BUILDING CODE OF AUSTRALIA CAPABILITY STATEMENT - Rev B
Property: Sydney Opera House – Eastern Accommodation, Joan Sutherland Theatre & Entry Foyer - SSD 7665 Submission

Table 1 – DoPE / GDLA Comments

1 PLAN - FOLLOW SPOT ROOM - DA
1 : 50

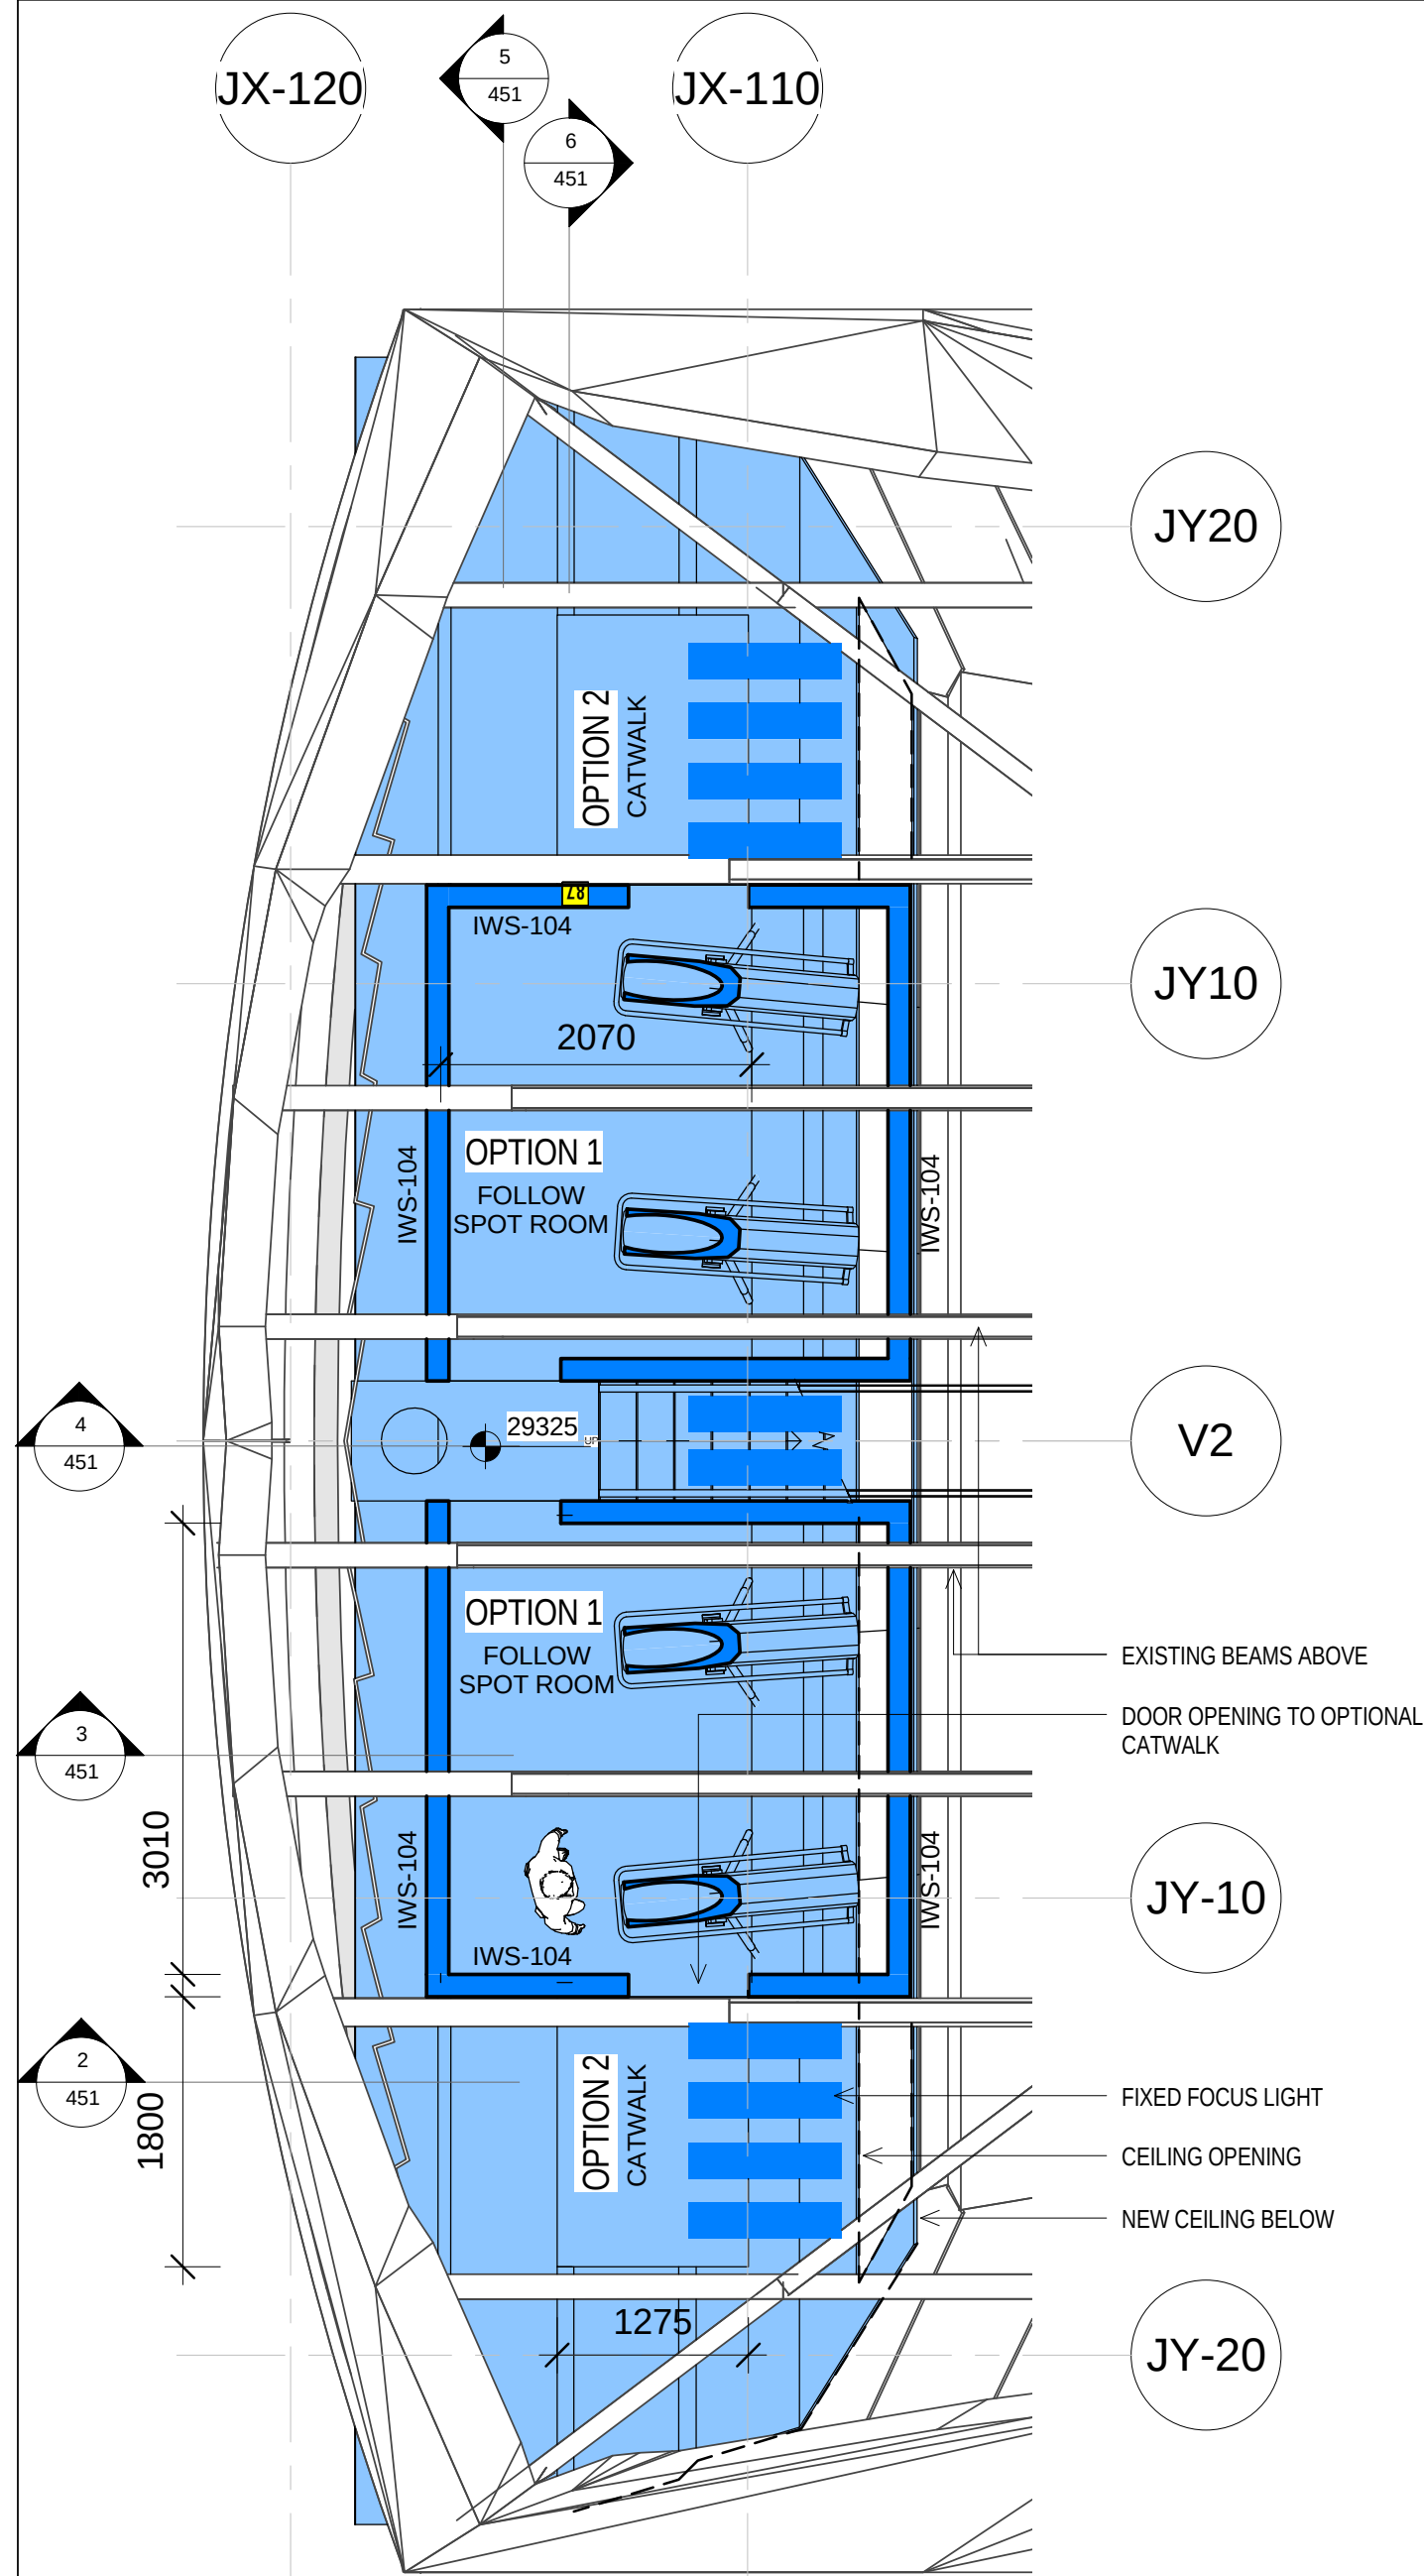
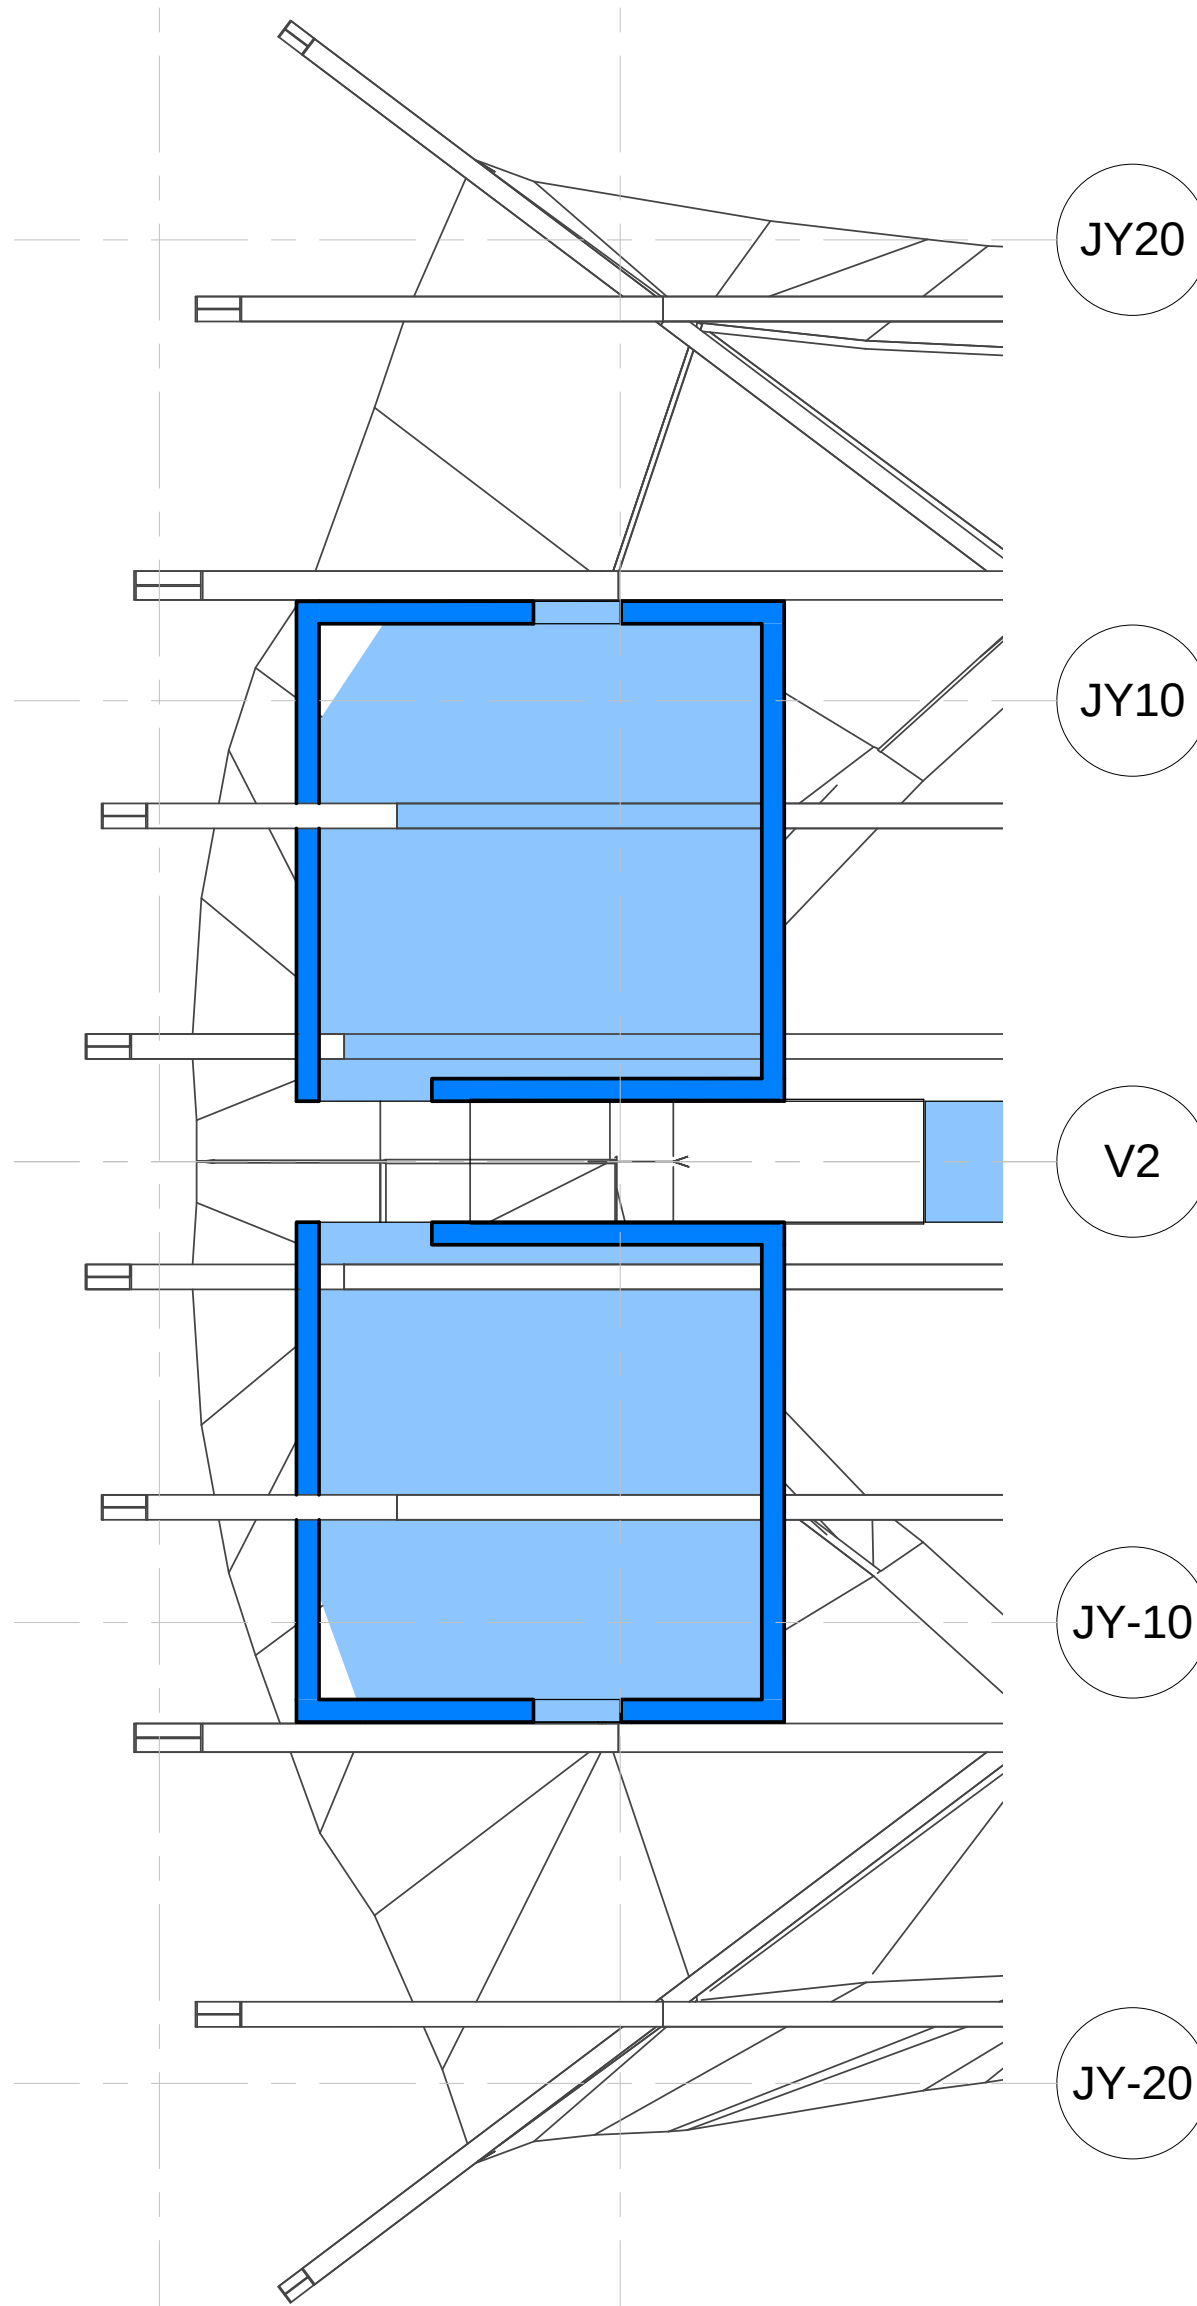
Department of Planning & Environment Comments	Group DLA Responses
The follow spot room: the capability statement indicates the level of detail provided did not enable a detailed assessment. The report shall be updated to confirm compliance or measures intended to achieve compliance.	Tender drawings have since been reviewed which contained a further level of detail to the extent that now allow Group DLA to confirm that a satisfactory intention to comply with the BCA is evident. Confirming that the Section 109R Crown Building Works Certificate to be issued by Group DLA for these related works will contain drawings/documents which satisfactorily illustrate an intention to comply with the BCA, as required. Confirming that the Crown Completion Certificate to be issued by Group DLA for these related works will be evidence of compliance with the BCA, as required.
Eastern offices and entry foyer: the report indicates the level of detail provided did not enable a detailed assessment. The report shall be updated to confirm compliance or measures intended to achieve compliance. A complete assessment of the essential fire and other measures is required in Section 5.0.	Tender drawings have since been reviewed which contained a further level of detail to the extent that now allow Group DLA to confirm that a satisfactory intention to comply with the BCA is evident. Confirming that the Section 109R Crown Building Works Certificate to be issued by Group DLA for these related works will contain drawings/documents which satisfactorily illustrate an intention to comply with the BCA, as required. Confirming that the Crown Completion Certificate to be issued by Group DLA for these related works will be evidence of compliance with the BCA, as required. A complete assessment of the essential fire and other measures is not required, reliance will be placed on the existing Annual Fire Safety Statement as is common practice and reasonable to expect. The Section 109R Crown Building Works Certificate will contain an updated Fire Schedule as required.
